Technical Memorandum

29 August 2023

To	Angus Walker	Contact No.	-
Copy to	Andrew Byrne	Email	-
From	Matthew East	Project No.	12578580
Project Name	DFDS Traffic Impact Study - Immingham		
Subject	IERRT – DFDS Written Response Addendum – Annual Throughput and Terminal Capacity

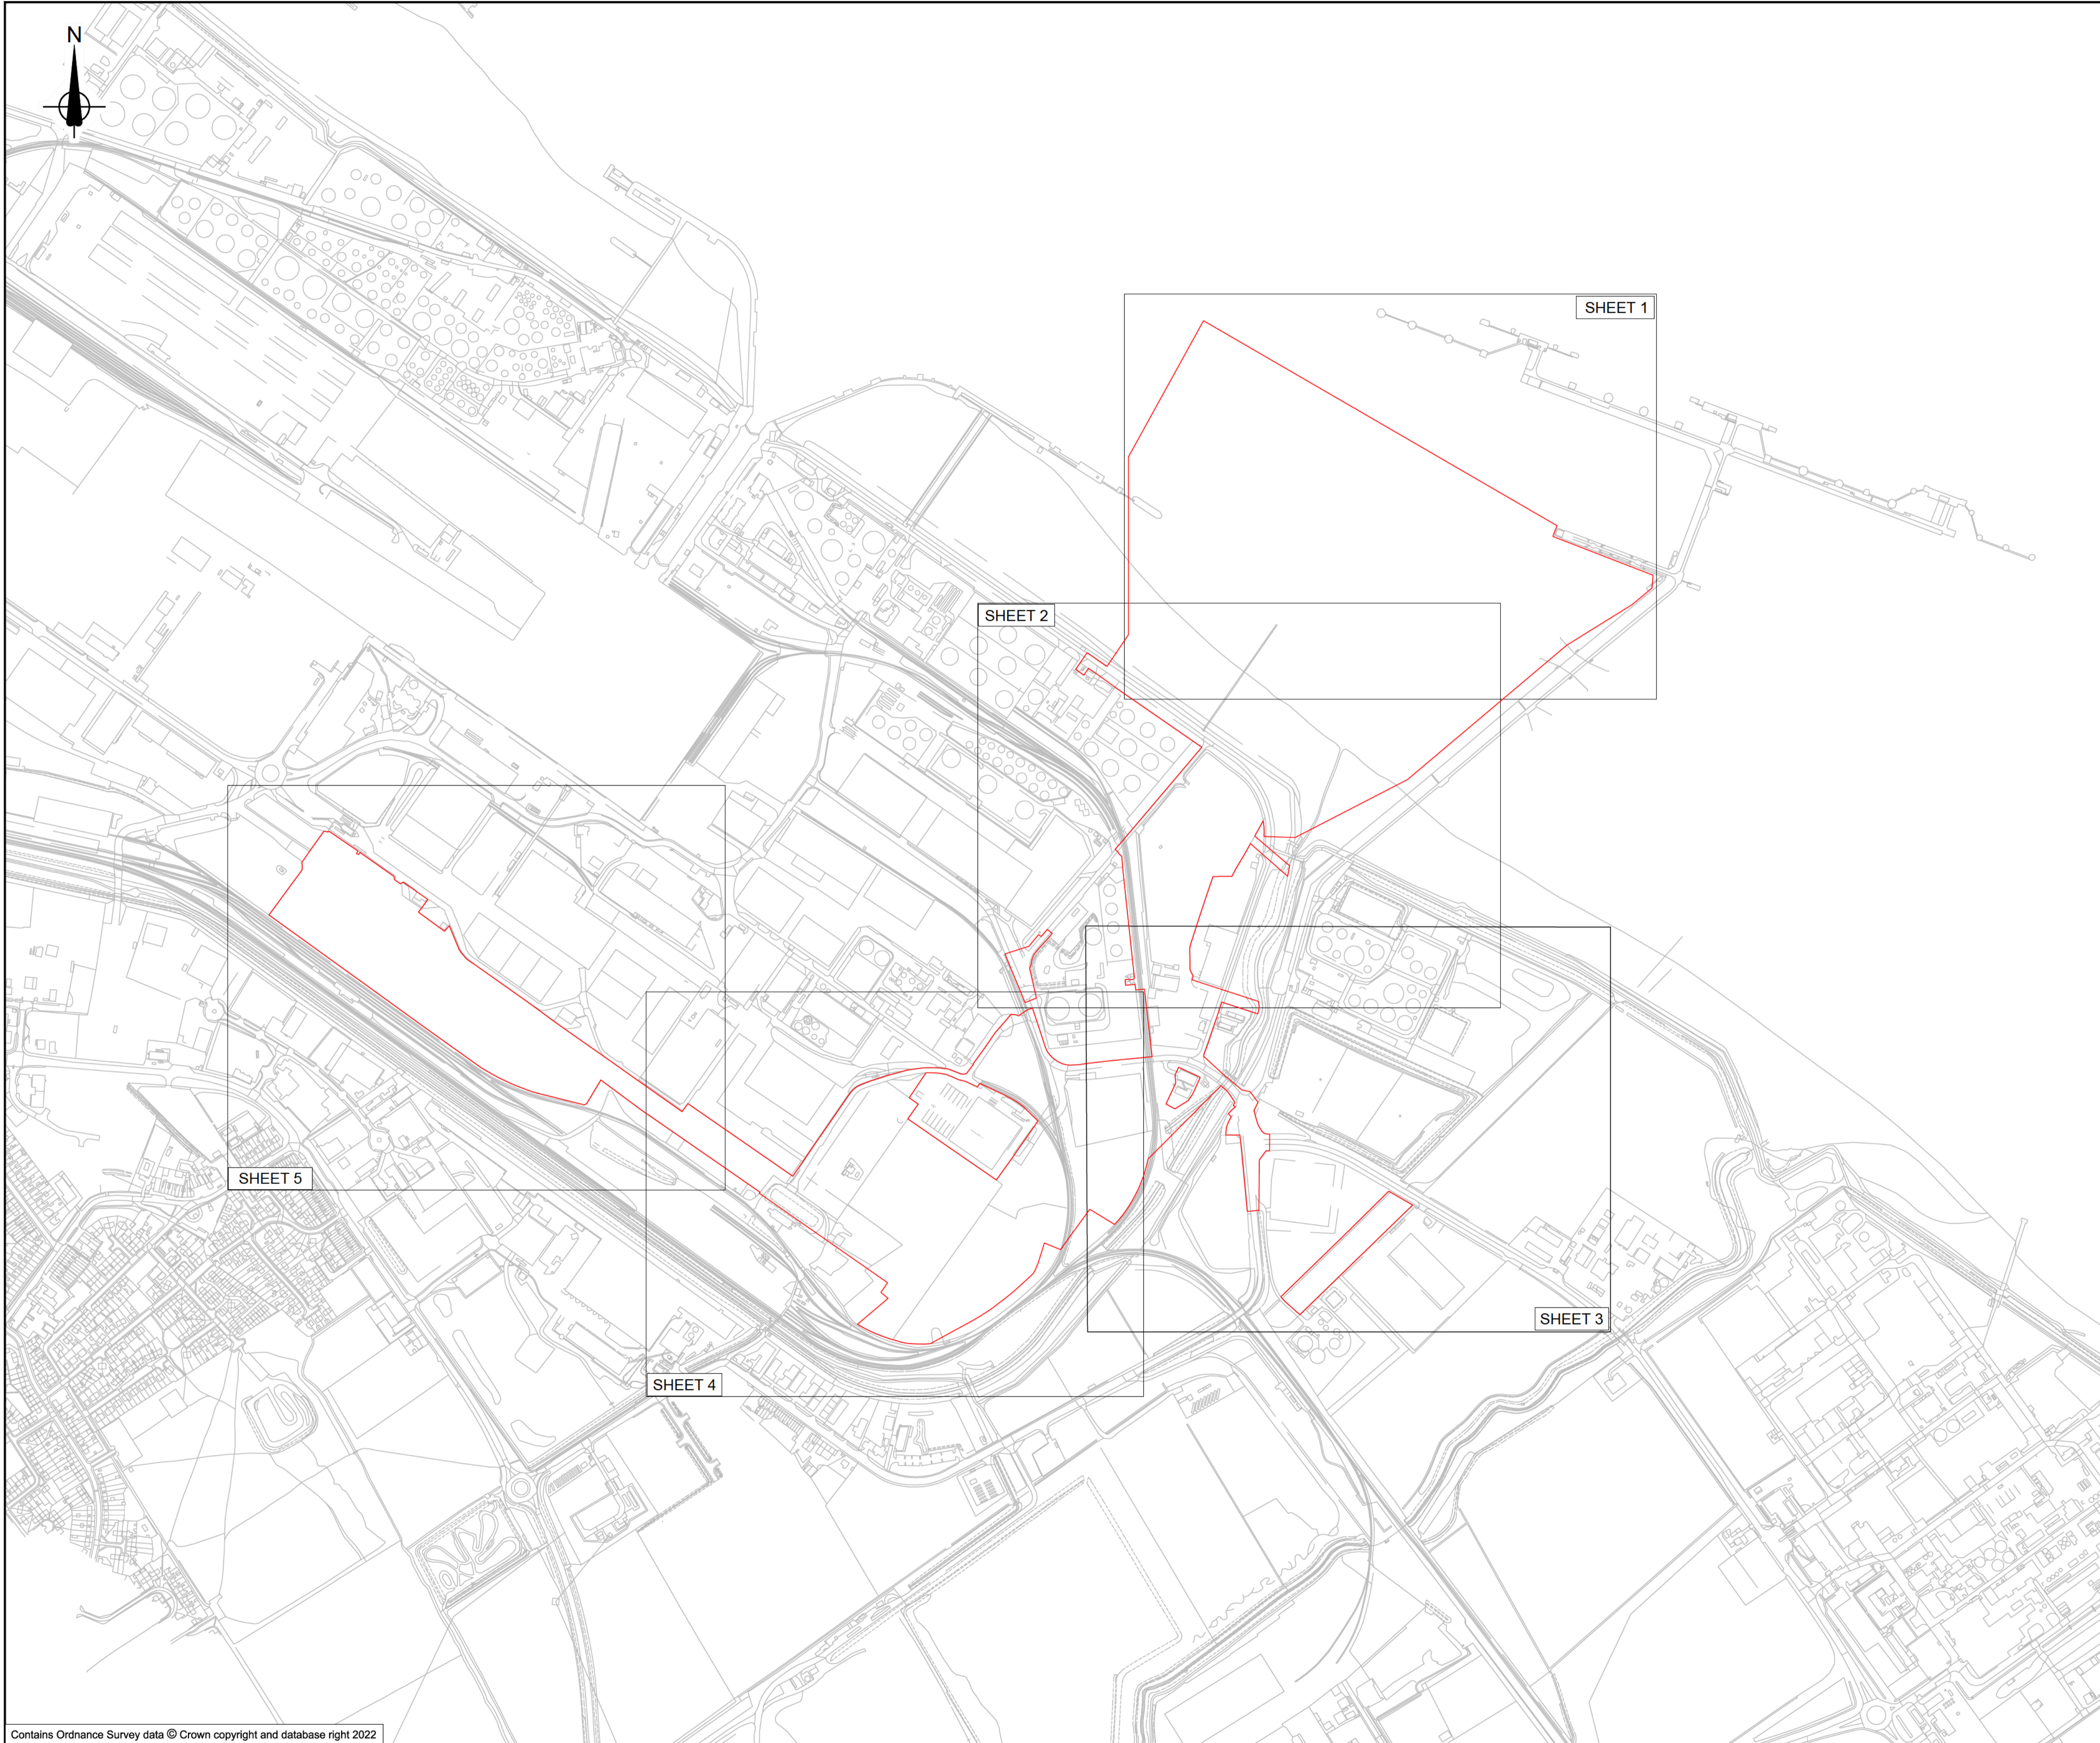
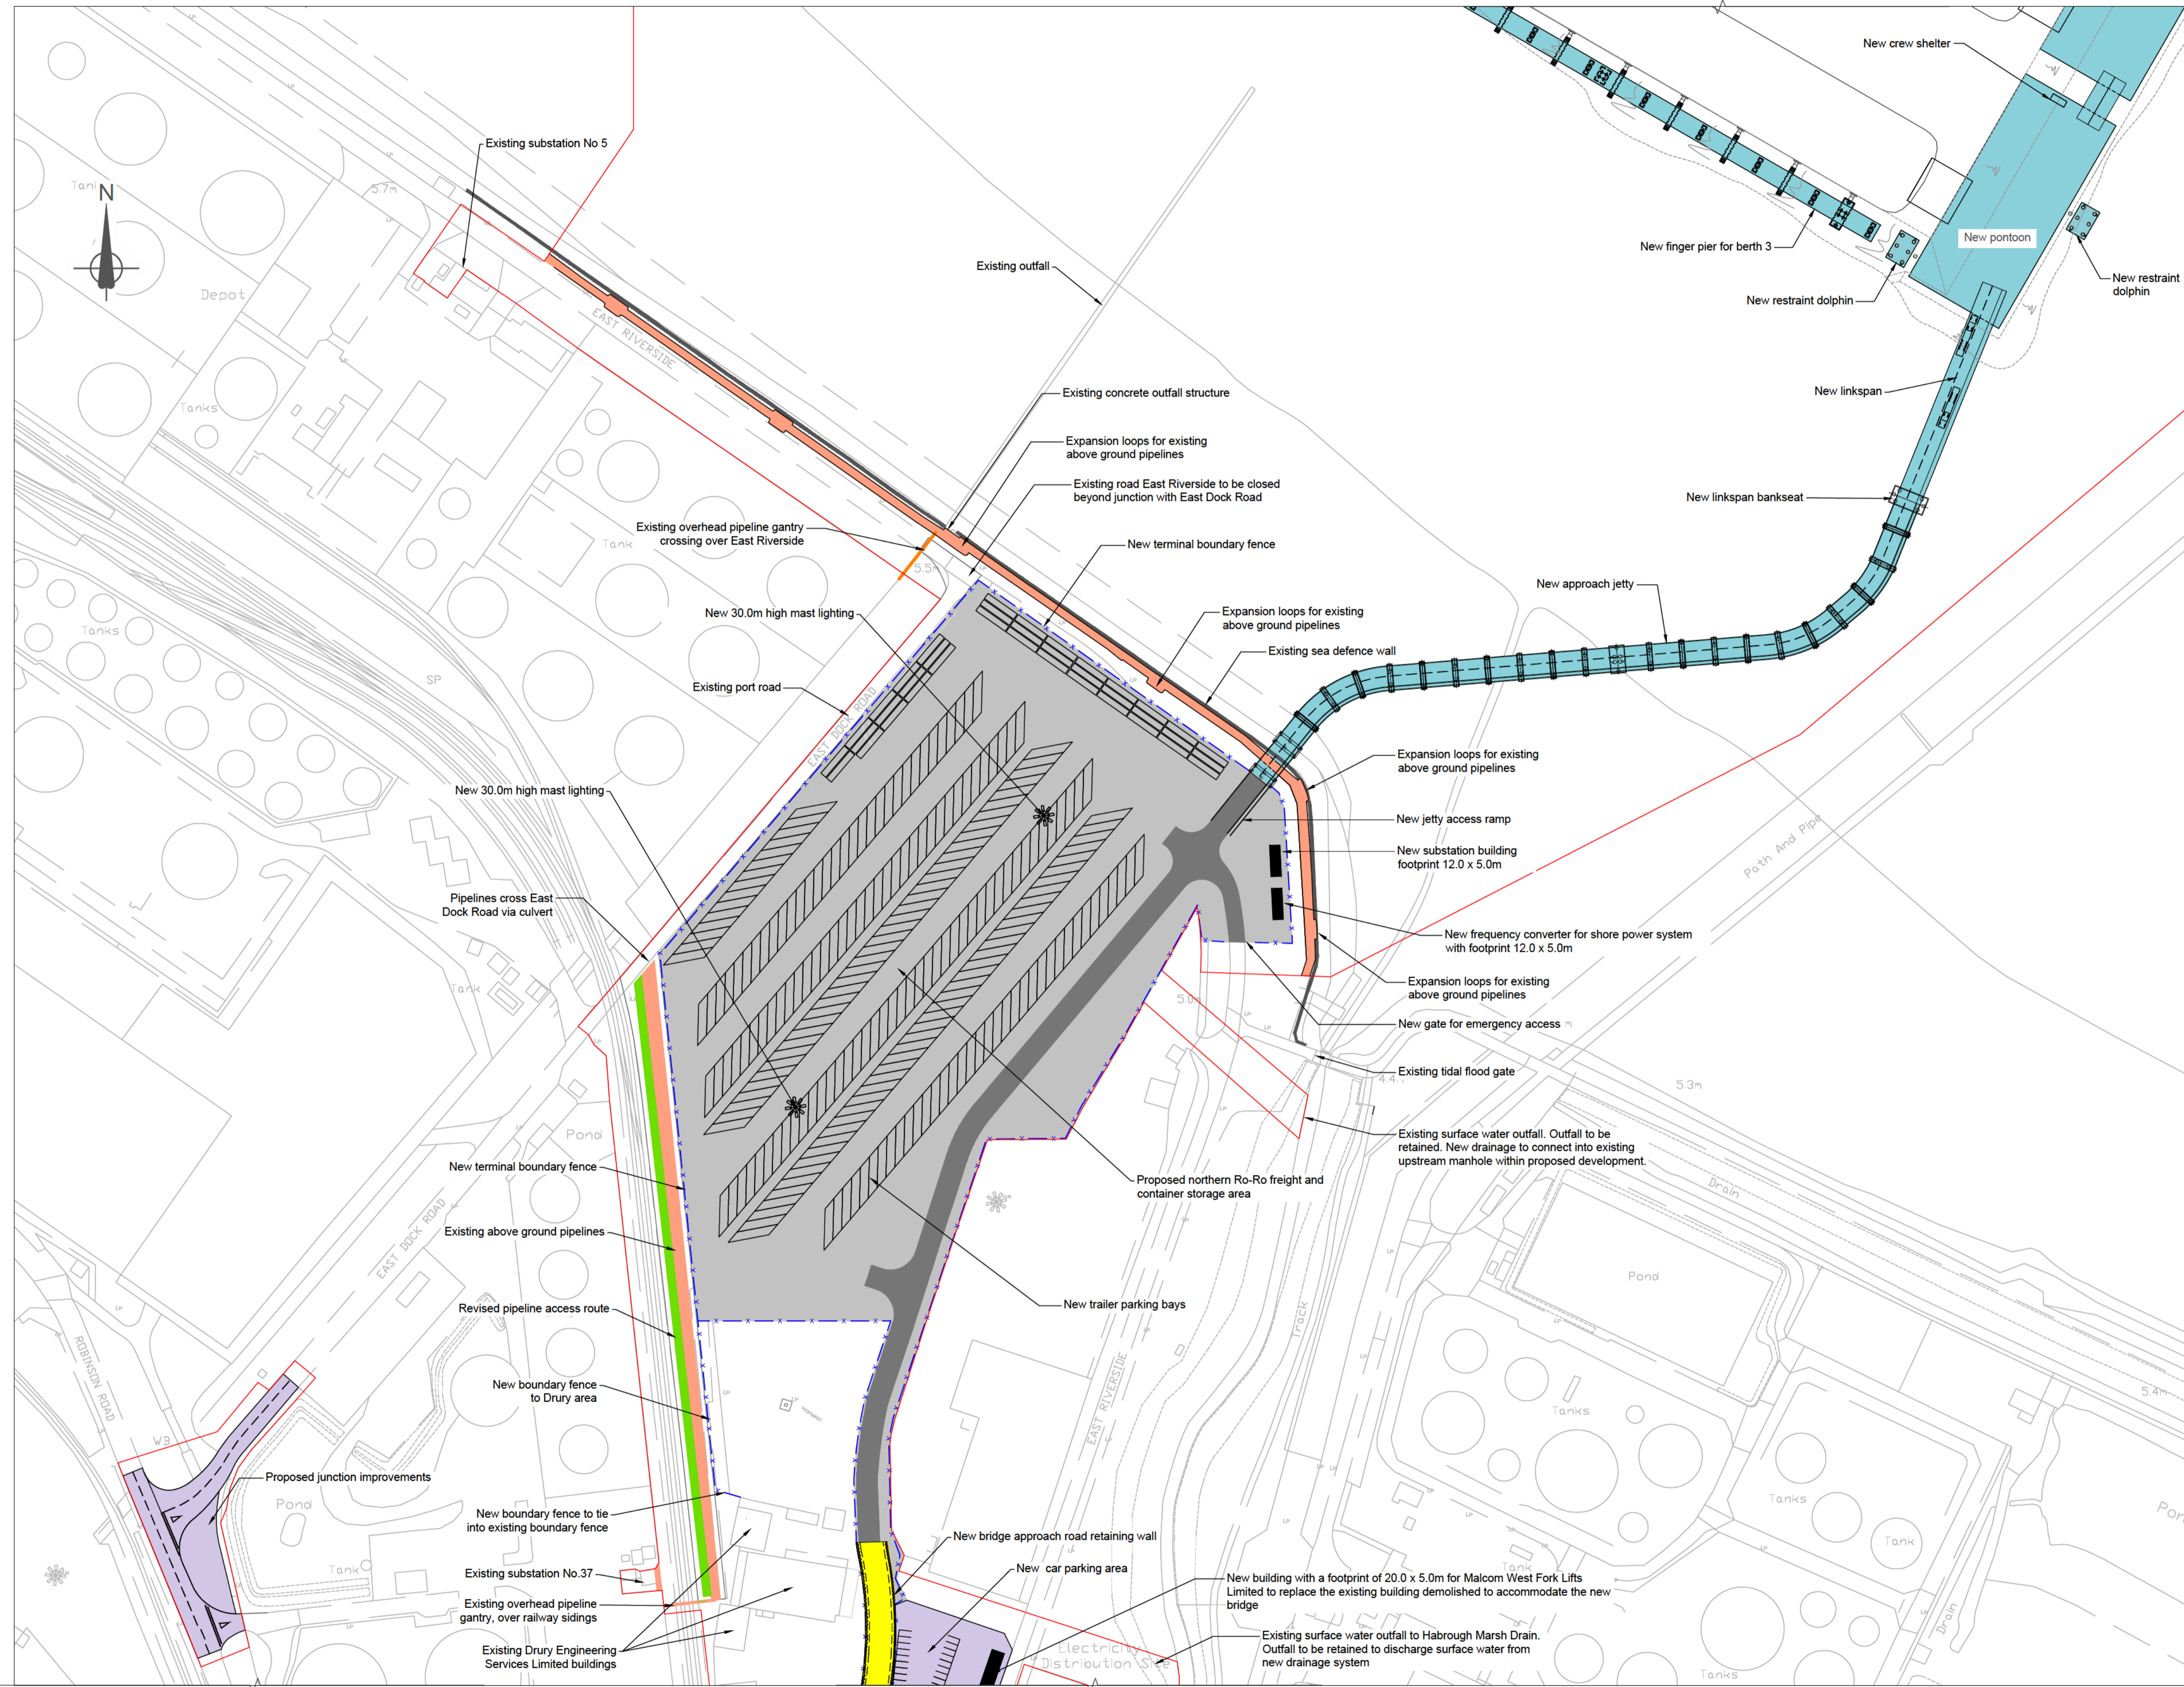
The intended configuration of the IERRT terminal is described within the Engineering Sections Drawings and Plans¹¹. These drawings identify:

- The location, stack height and number of slots for containers (slots are described in twenty foot equivalent units (TEU));
- The number of bays for trailer parking;
- Swimlanes for accompanied unit parking prior to boarding vessels; and
- Waiting areas external to the terminals security gates which are within the terminals boundary.

GHD have reviewed these drawings and identified the following approximate figures (note, as the files are only provided in pdf format, counting and measuring has had to be completed manually potentially leading to minor discrepancies in values presented).

Area	Lane Meters (m)	Container Slots (TEU)	Trailer Spaces (Units)
Northern	0	38	239
Central	0	0	157
Southern	1,420	0	355
Western	0	0	635
Total	1,420	38	1,386

Assuming a provision of 18 metres for each accompanied unit, and a stack height of three (3) containers per slot (as shown in the Engineering Drawings), the current terminal provides static capacity for:

- 79 spaces for waiting export accompanied units within the terminal, and a further 78 waiting spaces outside of the terminals gates (it is assumed imported accompanied units will not reside at the terminal, therefore spaces would only be utilised for exports);
- 114 TEU's (containers) for imports and exports; and
- 1,386 spaces for unaccompanied trailers for imports and exports.

Using the identified terminal configuration and operating assumptions, and assuming that on a peak day that all spaces are utilised within the terminal, the terminal configuration only has sufficient capacity if the dwell rate of unaccompanied and containerised is an average of around 2 days.

However, under the circumstance that all unaccompanied and containerised spaces are utilised, there is likely to be operational challenges generating congestion at the terminal gatehouse, which will in turn create delays for vehicles entering the terminal, leading to queuing back onto the port road network.

Further, for the terminal to handle 252 accompanied units to be loaded onto the departing vessel, the swimlanes provided to would need to be replenished in excess of 3 times (i.e. once per vessel). This would mean that the applicant would need to ensure that boarding of the vessels is completed against a controlled schedule. This is also operationally complex and has a high potential of resulting in congestion and queuing on the port road network.

Based on operational parameters identified and carrying over the average dwell rate of 2.1 whilst factoring in the estimated peaking factor based on DFDS operations of 122%, the terminal is estimated to have an annual capacity of just under 300,000 RoRo units per year¹⁸. In a simplified view, this is determined by the following equation:

This is substantially less than the quoted maximum of 660,000 units per year. This supports the applicants consultant view that the terminal acts as a physical control on the annual throughput and the maximum volume in the dDCO would not be achievable.
